EIS SSD-52066209 Macarthur Health Precinct Stage 2

I refer to the Department's email of 14 December 2023 from NSW Department of Planning and Environment regarding the Environmental Impact Statement (EIS) for State Significant Development SSD-52066209 Macarthur Health Precinct Stage 2 for 'Demolition of the existing library and construction and operation of a health services facility including day surgical hospital, medical office building and other supporting health services' at 1 HURLEY STREET, CAMPBELLTOWN 2560 (Lot 1002 DP 873452) in the Campbelltown City Council Local Government Area (LGA). Submissions need to be made to the Department by 31 January 2023.

Endeavour Energy has noted the Infrastructure Delivery, Management and Staging Plan dated 25 October 2023 prepared by DSA Consulting includes as Appendix 1 a copy of a Technical Review Request (Endeavour Energy Ref. ENL4702 - 1002) dated 16 May 2023 which indicates a new padmount substation is required on the site. The following extract of the Proposed Site Plan shows provision for a substation to the Camden Road road frontage.

Drawing Name
PROPOSED SITE PLAN

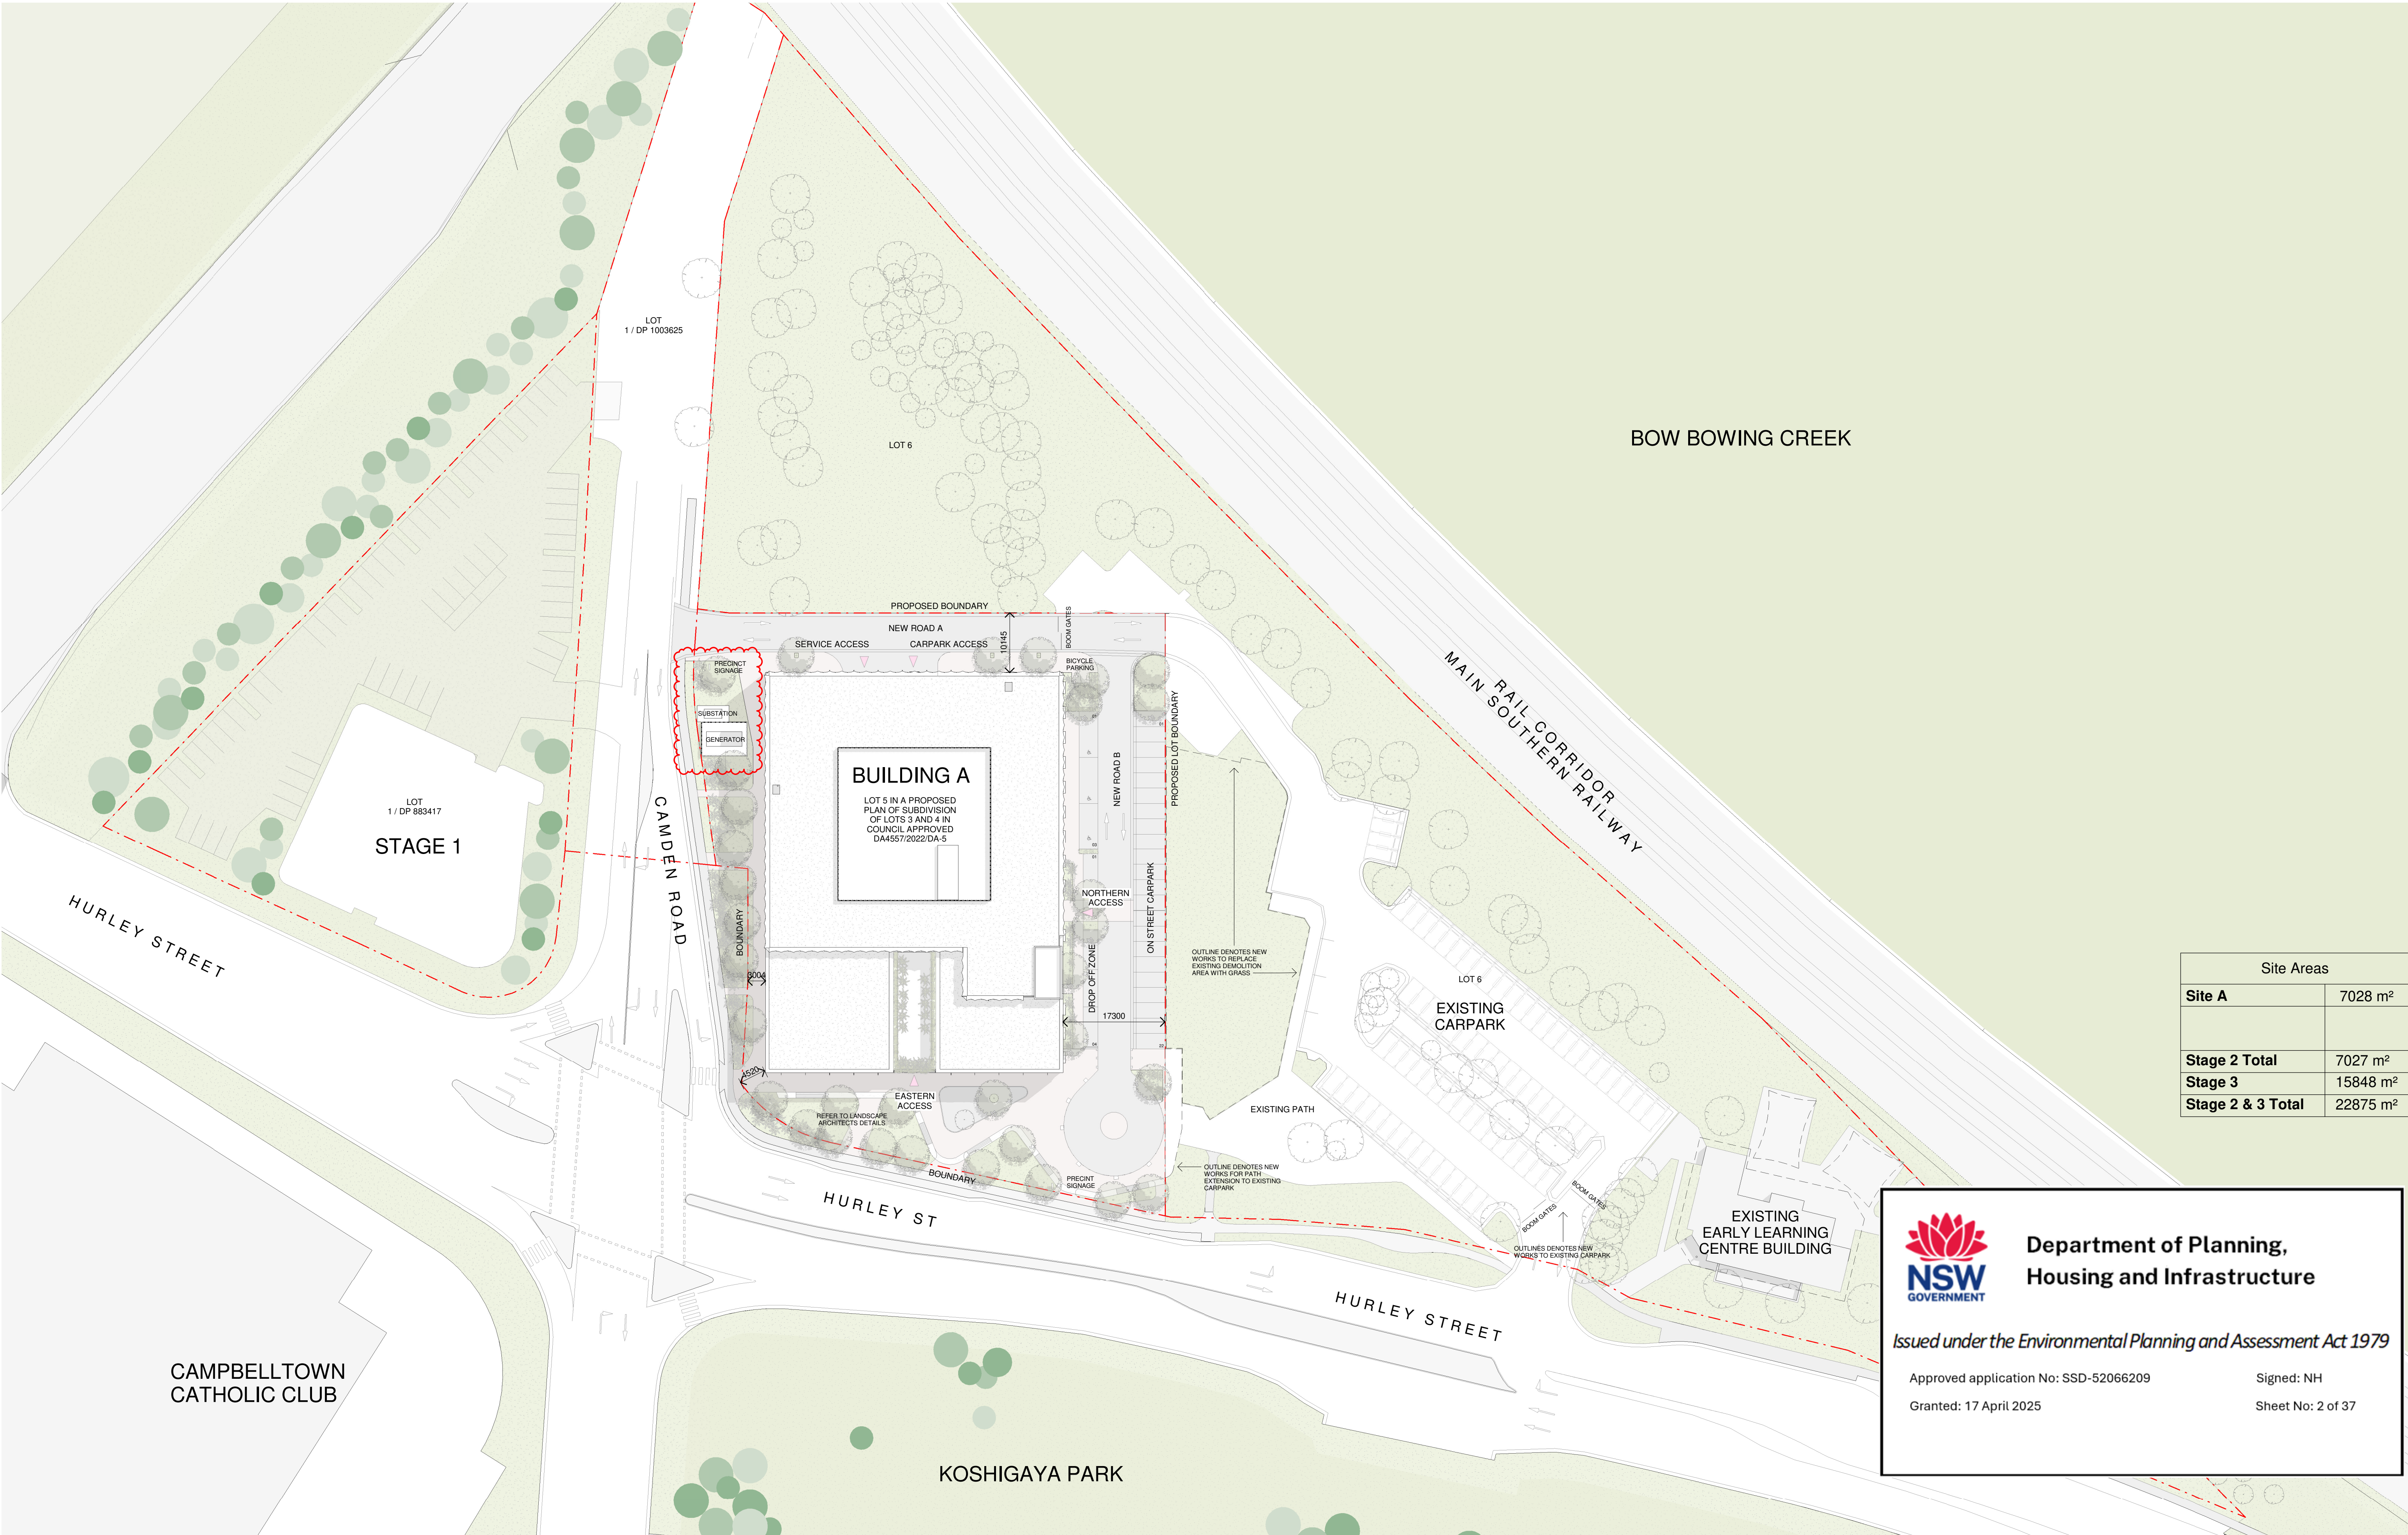
Any required padmount substation/s will need to be located within the property (in a suitable and accessible location) and be protected (including any associated cabling not located within a public road / reserve) with an appropriate form of property tenure as detailed in the attached copy of Endeavour Energy's 'Land Interest Guidelines For Network Connection'.

Generally it is the Level 3 Accredited Service Provider's (ASP) responsibility (engaged by the developer) to make sure substation location and design complies with Endeavour Energy's standards the suitability of access, safety clearances, fire ratings, flooding etc. If the substation does not comply with Endeavour Energy's standards, the applicant must request a dispensation.
